**MEDOWIE ROAD (MR518): SSD 8989, NEW CATHOLIC COLLEGE – ‘CATHERINE MCAULEY CATHOLIC COLLEGE, LOT: 413 DP: 1063902, 507 MEDOWIE ROAD, MEDOWIE**

## Attachment A - Roads and Maritime Design Review (Revision 2)

<b>Transport Roads &amp; Maritime Services</b> Engineering Services Road Design	Project Title	Proposed Signalised intersection- Catherine McAuley Catholic College – 507 Medowie Rd and South St – Medowie		DESIGN REVIEW		
	Road No.	Design Organisation	Drawing No.	ROAD ENGINEERING		
	MR518	MPC	17-828	This design review by the Roads & Maritime Services (hereafter referred to as "RMS") covers an examination of the provided drawings and report to determine if they conform to RMS policy and practice. The review is not a proof check or a dimensional check and may not be complete.		
Review requested by:		Review performed by:		Project Status	Issue No	Review Issue Date
01 – Kylie-Anne Pont, Development Assessment Officer, RMS Hunter 02 – Kylie-Anne Pont, Development Assessment Officer, RMS Hunter		01 – Greg Pollard (GP), Designer, Design Newcastle, Engineering Services, RMS 02 – Greg Pollard (GP), Designer, Design Newcastle, Engineering Services, RMS		01 – Strategic 02 - Strategic	01 –

Figure 4 | Temporary intersection design (Source: Applicant's Modification Report)

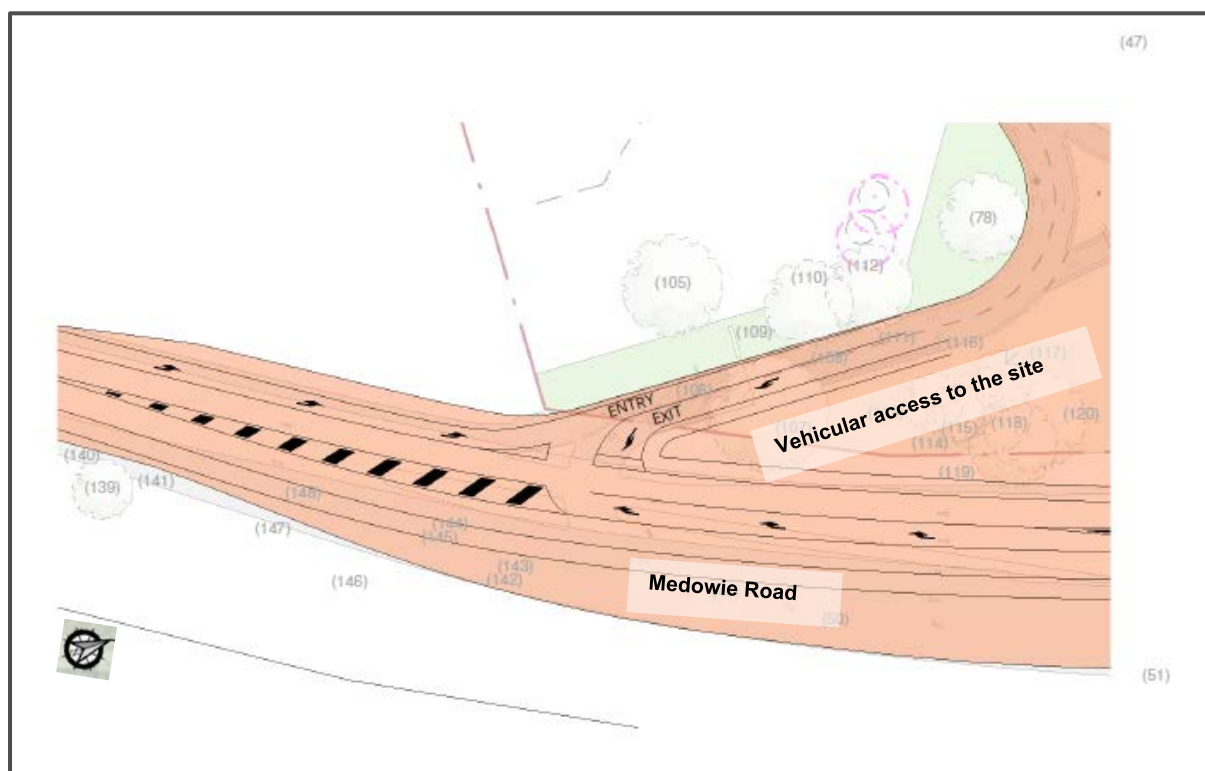
- The concept TCS design does not meet the standards of *Austrroads Guide to Road Design 2010* and associated supplements as the concept intersection has not been designed to the prevailing speed limit. The intersection has been designed for a 40kph school zone however the proponent has advised that the site will be used outside school peak periods.

Please see *Attachment A – Roads and Maritime Design Review (Revision 2)* to be addressed by the proponent. Following a review of the design comments by the proponent, Roads and Maritime recommends the concept intersection design be revised to comply with Austrroads and relevant supplements and Australian Standards.
